**KIRKLEES METROPOLITAN COUNCIL
INVESTMENT & REGENERATION SERVICE**

**DELEGATED DECISION TO DETERMINE APPLICATIONS FOR
CONSENT, AGREEMENT OR APPROVAL REQUIRED BY CONDITION**

Reference No:	2023/44/91600/W
Site Address:	land adjacent, Manchester Road, Huddersfield
Description:	Discharge of conditions 6 (sheltered cycle parking), 16 (electric vehicle charging) of previous permission 2014/90411 for erection of 2 blocks of student accommodation
Recommending Officer:	Ellie Worth

Application: 2023/91600

DRAWING
Block B Ground Floor
Proposed

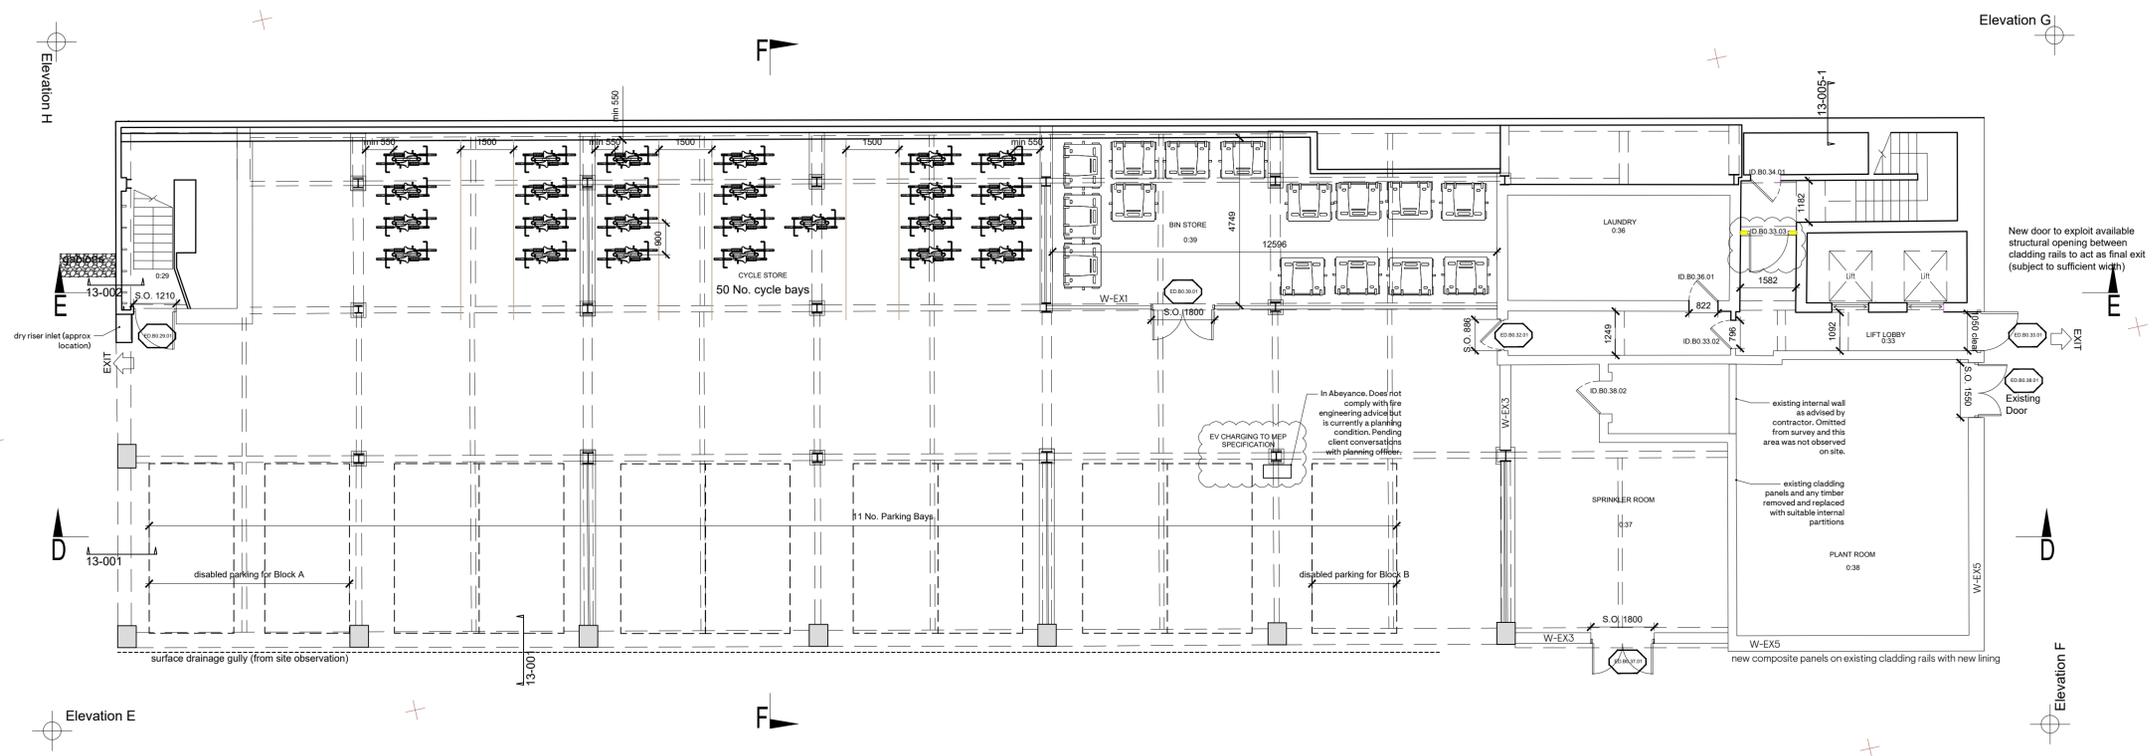
A plan labelled Block B Ground Floor Proposed (drawing HUD-KKA-BB-00-DR-A-03-011) has been submitted in support of this condition.

The plan demonstrates adequate space for the storage of 50 bikes, in line with the aforementioned condition.

The information submitted is acceptable, subject to the facilities being retained free of obstruction and available for use, throughout the lifetime of the development.

The information submitted is acceptable for the purpose of condition 6. It is noted however, that the facilities should be retained free of obstruction and available for use, throughout the lifetime of the development.
